Current Zoning: RE-3 (research)

Proposed Zoning: I-2(CD) (general industrial, conditional)  
Approximately 63.22 acres located on the north and south side of Morris Estate Drive, east of North Graham Street, and west of IBM Drive.

The petition proposes to allow up to 325,000 square feet of light manufacturing, assembly, warehousing, climate controlled self-storage, offices, outdoor storage, and wireless communication as well as other principal and accessory uses permitted in the I-2 district. The site is currently developed with manufacturing and warehousing uses.

Staff recommends approval of this petition.

RZ-1

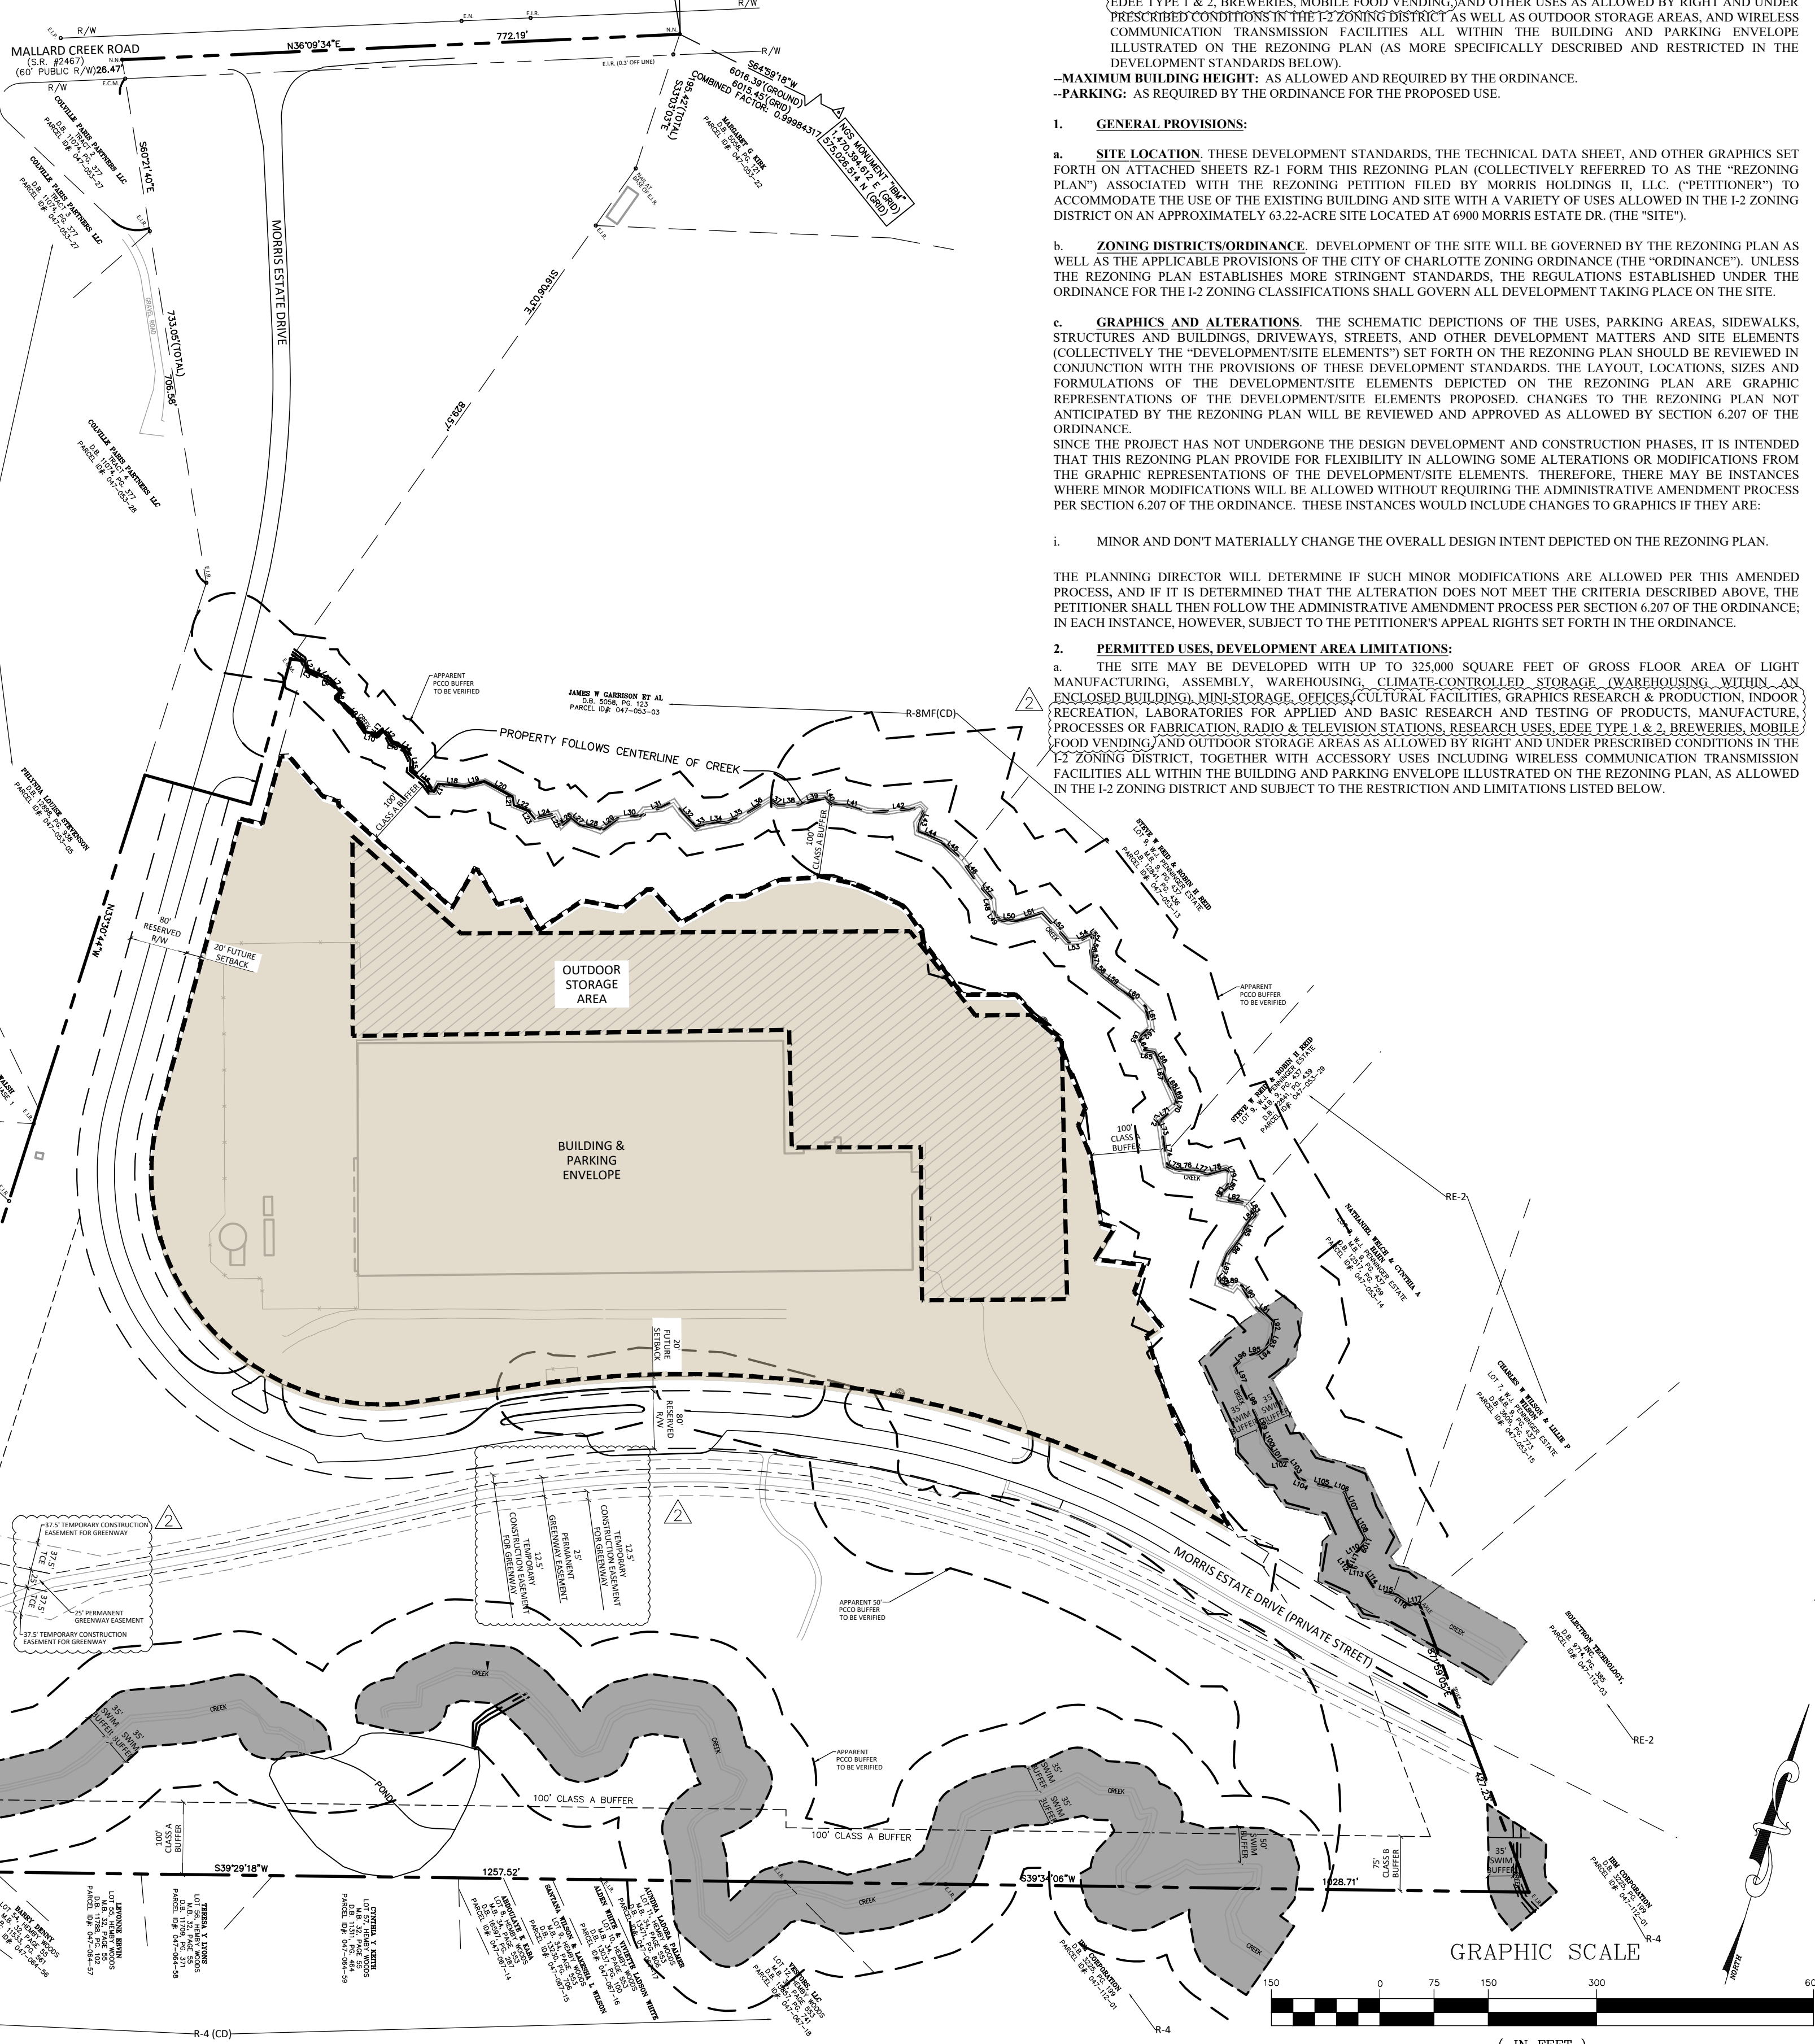
- ~~1. The previous submitted site plan identified the 100' greenway easement area adjacent to Morris Estate Drive. MCPR requests that the proposed easement be consistent with this initial proposed area, with the addition of the connection to Nevin Road. Addressed~~
